DECISION DELEGATED TO HEAD OF PLANNING

Application No: H08-0846-25 **Applicant:** Mr A Murfet
Proposal: Proposed dwelling
Location: Adj 3-4 Bowgate Gosberton Spalding
Terminal Date: 4th November 2025

Figure 4- Proposed site layout

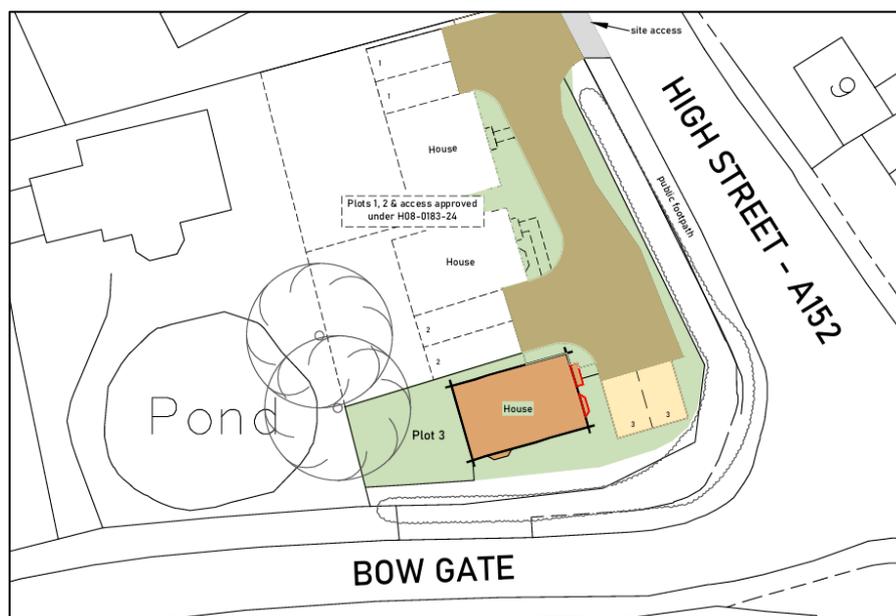
The dwelling is proposed to feature a similar layout and appearance as the southern dwelling, however, the proposal would result in a smaller garden area for the southern dwelling. It is considered that this would result in a cramped form of development, particularly given the surrounding character and appearance of the area which features more spacious plots. As the site comprises a corner plot, the proposed dwelling would be visually prominent within the street scene. Most of the dwellings on Bow Gate are set back from the road frontage at similar distances. 3-4 Bow Gate, is set back even further than the other nearest dwellings on Bow Gate. The proposed dwelling in this instance would result in development further forward than the general building line. It is considered that this would result in a cramped form of development that would not respond positively to the street scene on Bow Gate.

Overall, the development would appear at odds with the surrounding built environment, visually, creating an incongruous final form of development which would be harmful to the appearance of the locality and to the character of the area. This is particularly the case given the nature of the corner plot which would be highly visible in the street scene and would erode the openness and character of the site. As the benefit associated with the creation of one single dwelling, is not considered to outweigh the harm that would arise in this regard when weighed in the planning balance.

The proposed development would result in the loss of external amenity space for the most southerly dwelling that was approved under permission H08-0183-24. This dwelling would be left with a rear garden measuring approximately 96sqm. Whilst this is considered to be a sufficient amount of external amenity space, it is likely that a portion of the garden would experience shadowing from

The proposed dwelling would be located approximately 6.5m to the south of the nearest dwelling that was approved under permission H08-0183-24. Whilst this would reduce the outlook of some of the habitable rooms within the dwelling to the north of the site, it is not considered that this would create an overbearing impact as there are windows on the front and rear elevations which provide other opportunities for an outlook from these rooms. The proposal would nonetheless result in some harm to the amenity of future occupants of the dwelling to the north.
